Re: 330 Church St, Parramatta – MP10_0171 MOD 8

We write to express our objection to the Application. In short, we do not understand how the Department of Planning and Environment (**Department**), acting reasonably, can approve an Application that will lead to the amplification of a serious and dangerous traffic and pedestrian conflict.

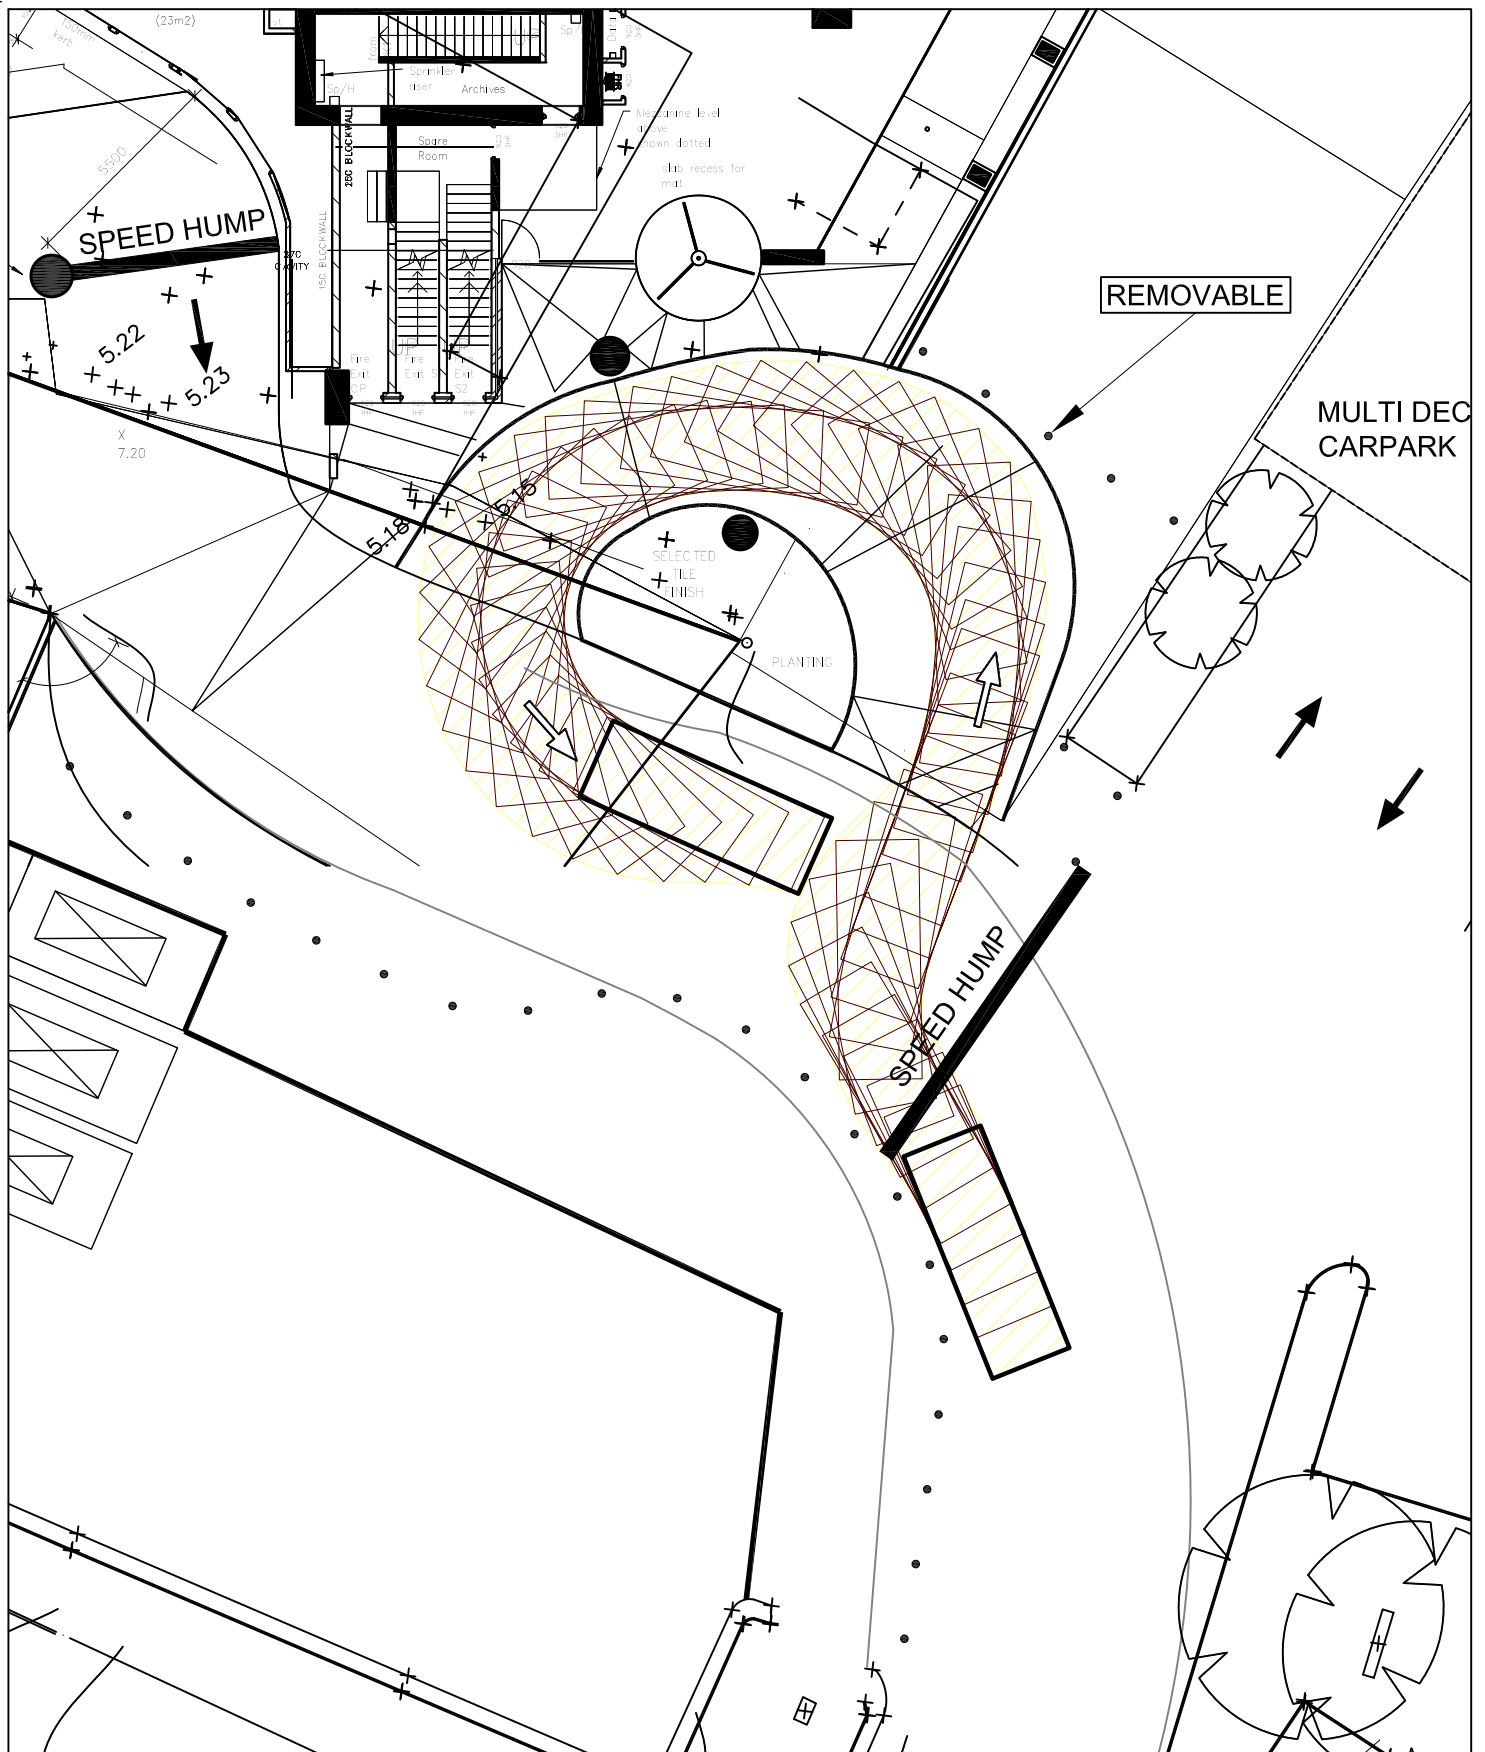
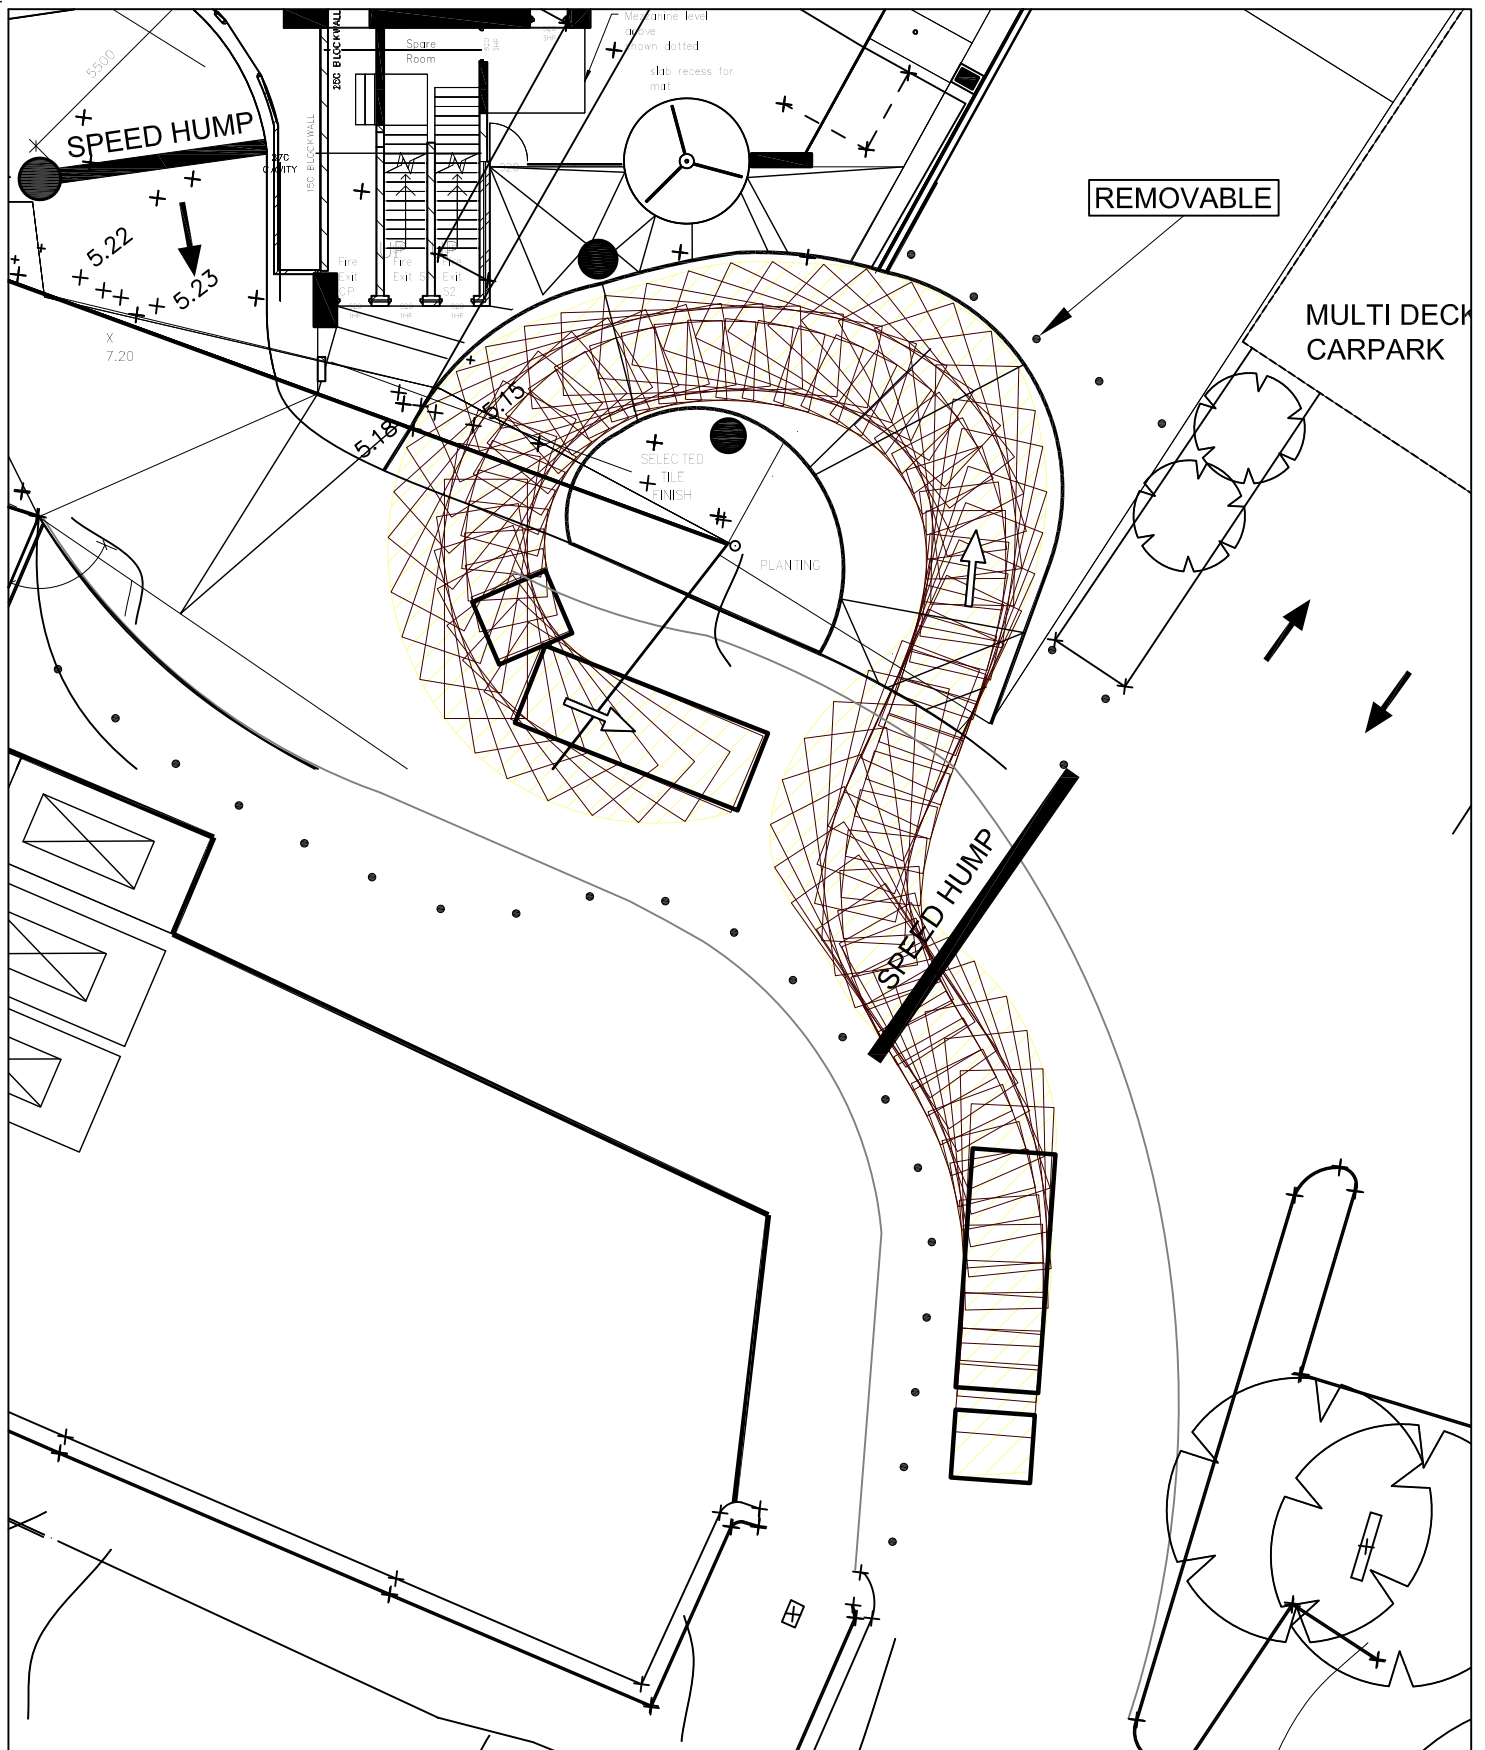
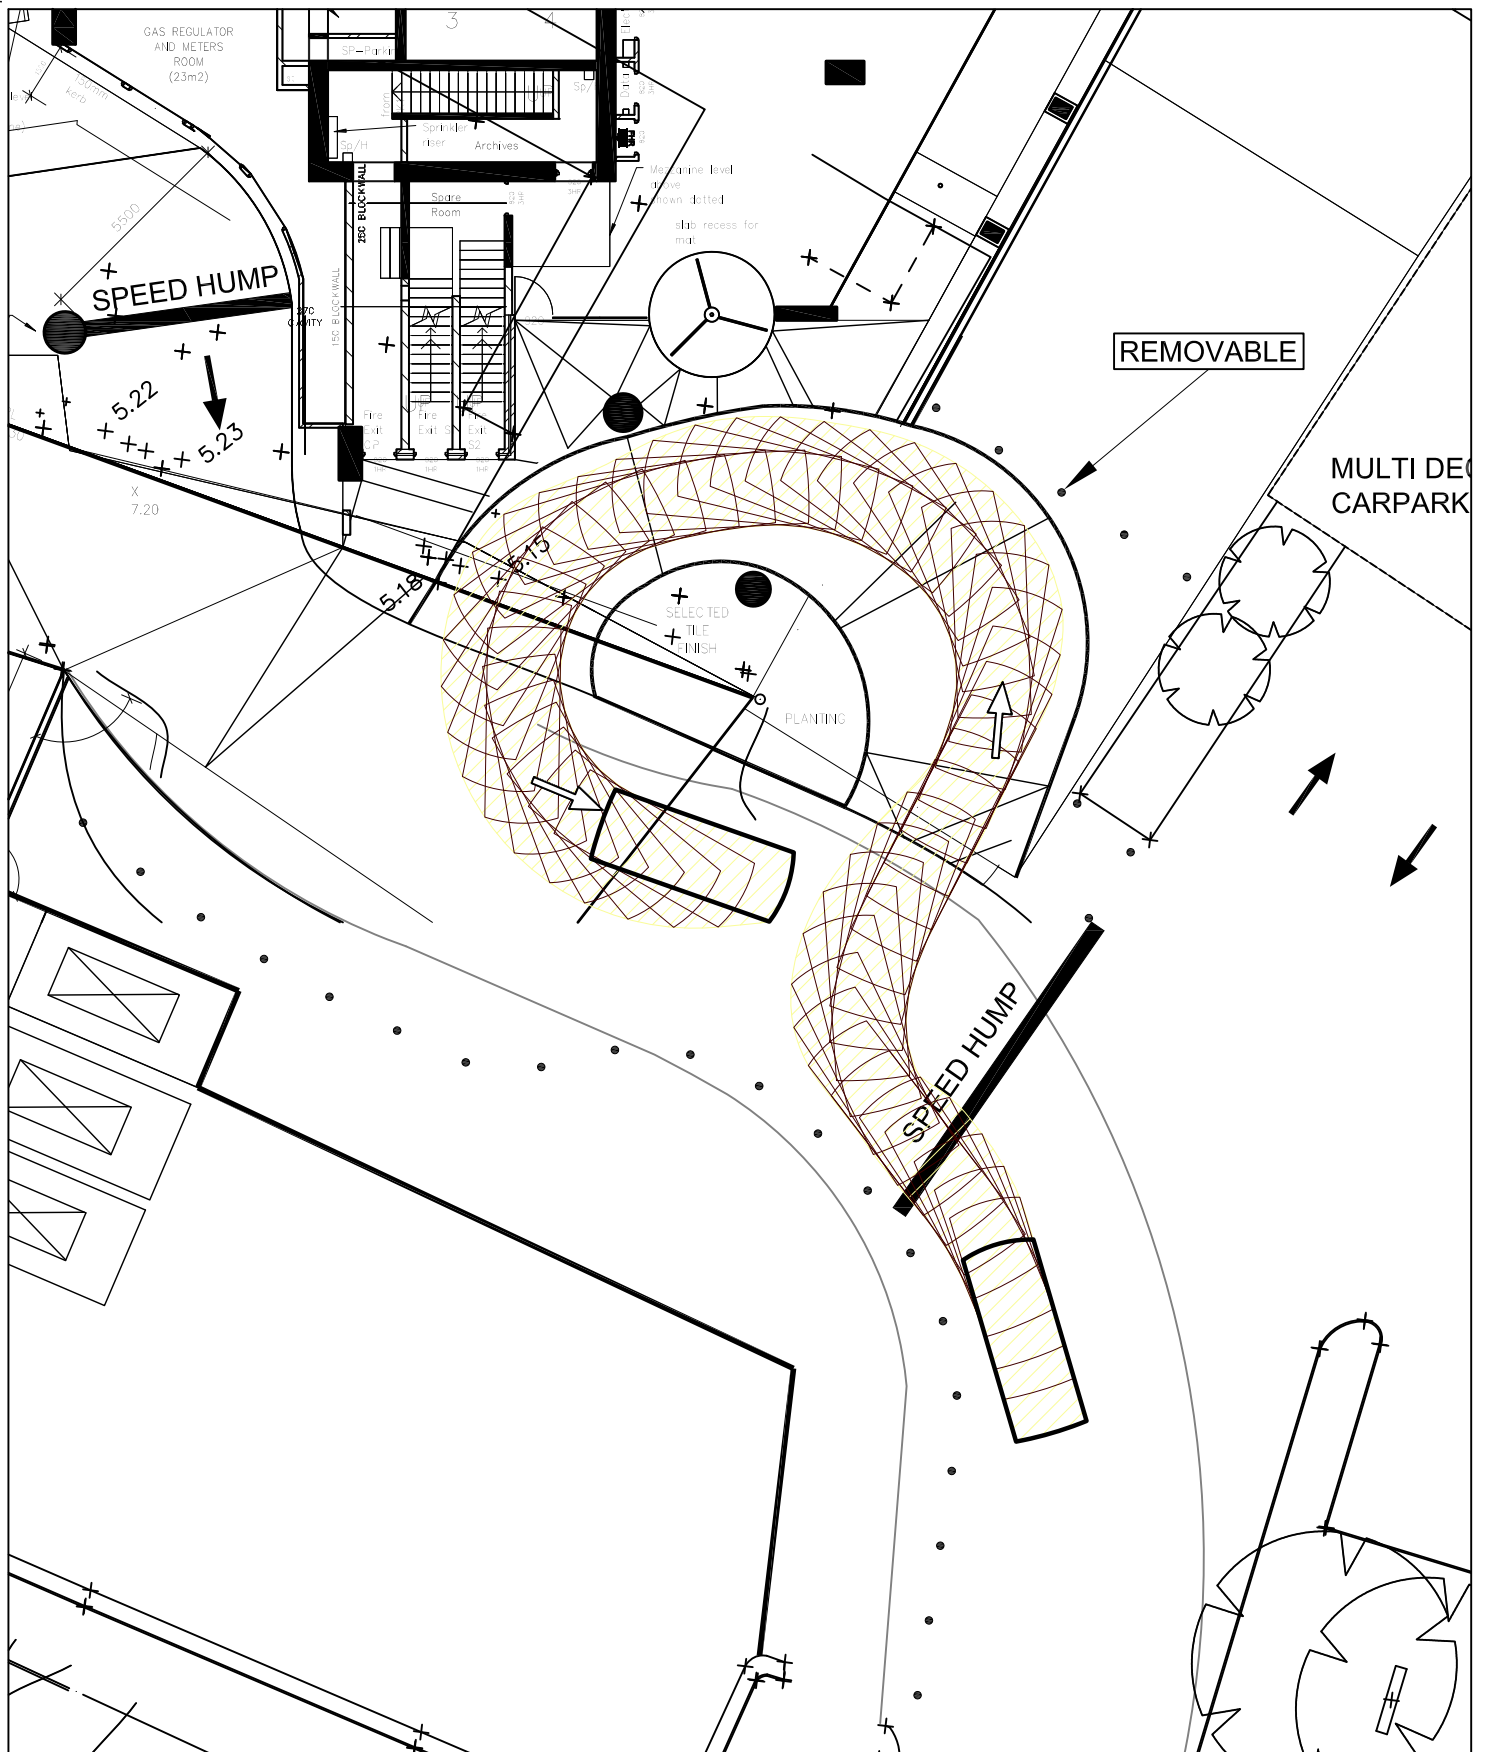
Secondly, the porte cochere modification is not supported by any traffic or safety analysis that calculates the increase in traffic movements; analyses the implications for traffic safety; reviews the way in which pedestrian safety is provided; considers the management of loading, unloading, garbage, deliveries, resident access, visitor parking; and gives an estimate of the porte cochere use and the relationship with other traffic movements in this very small area of land. The traffic analysis is limited to simply the swept turning paths for vehicles.

Clearly a proper traffic, pedestrian and safety analysis should consider more than the “workability” of a driveway, but should thoroughly review the cumulative impacts of the proposal, taken together with other traffic and pedestrian generating uses in immediate proximity to the site.
